Subject: BL-25-00013 DCYF - Notice of Application

Please review the following Boundary Line Adjustment Application: BL-25-00013 DCYF. Any comments need to be received by **5 PM on October 15, 2025**.

TO: All Staff
FROM: Public Works Plan Review Team
DATE: October 13, 2025
SUBJECT: BL-25-00013 DCYF

RECORD OF SURVEY

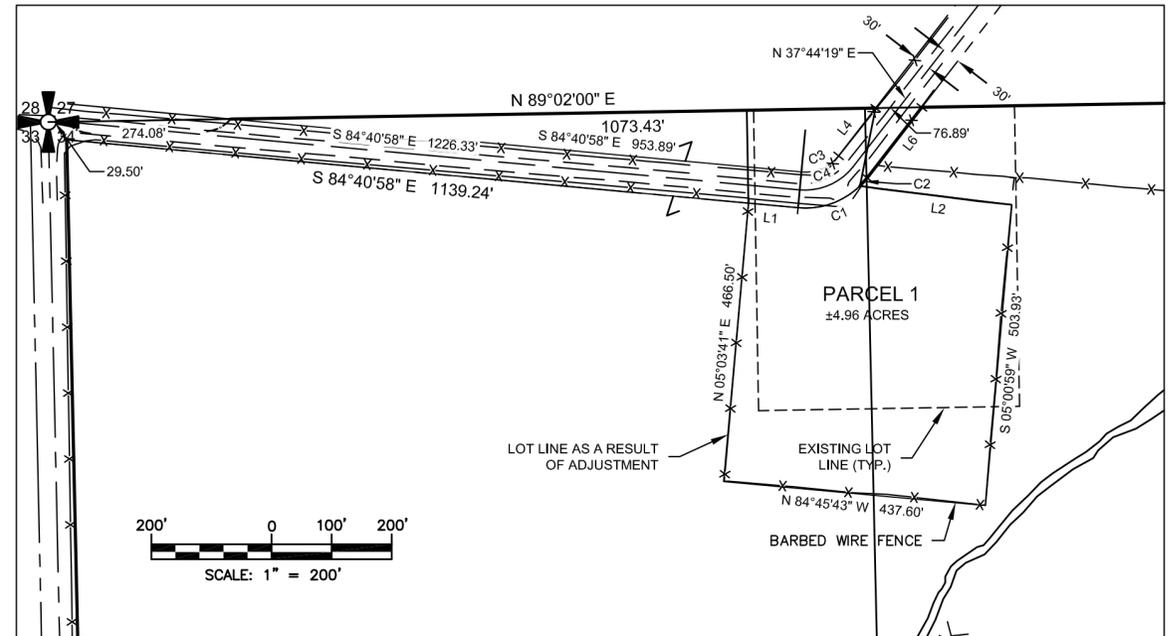
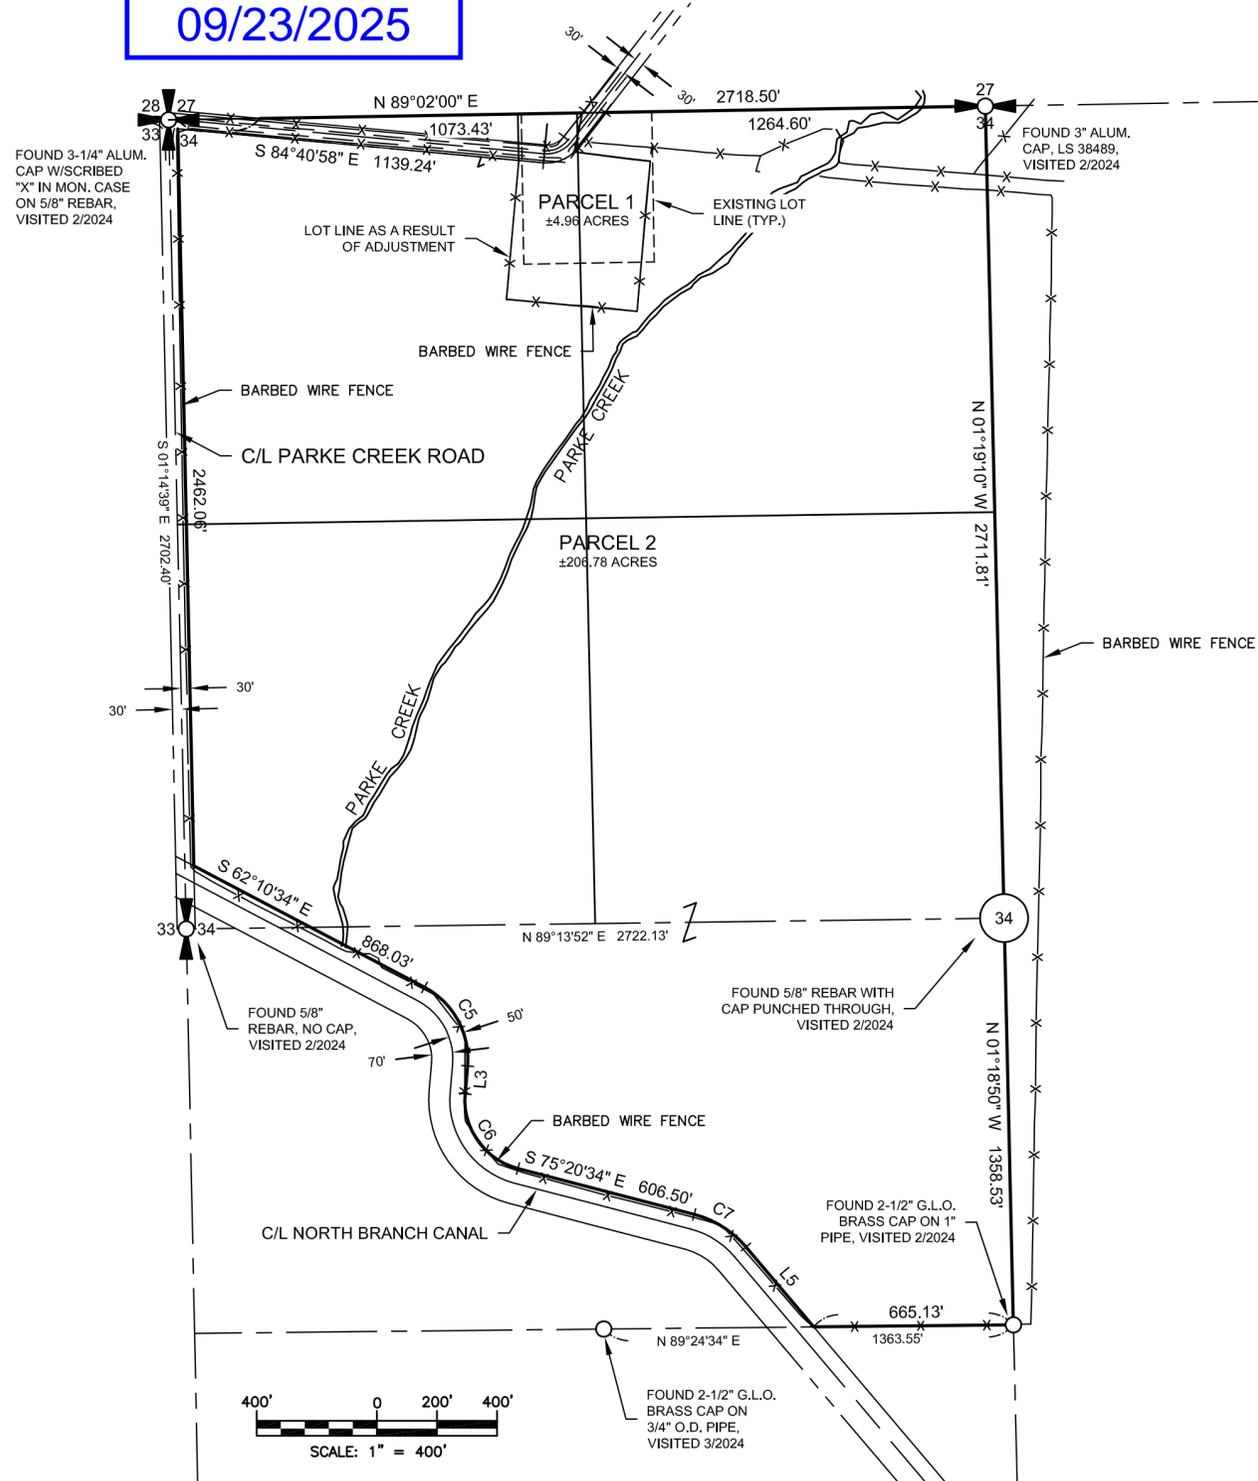
SURVEY	<ol style="list-style-type: none"> 1. Please correct text obscured by crossing linework, including the area of Parcel 2, the distance along the W' most sec line, and the label for Parke Creek. 2. Please identify the 3 solid lines crossing Parke Creek Rd. located north of Parcel 1. 3. Please clarify the distance ties of 29.5 and 274.08 Near the NW corner of Section. 4. Please identify or note the Basis of Bearing. <p>OF NOTE Lot Closures were not provided or reviewed for this project. (JT)</p>
TRANSPORTATION CONCURRENCY	<p>No Comments. (RC)</p>
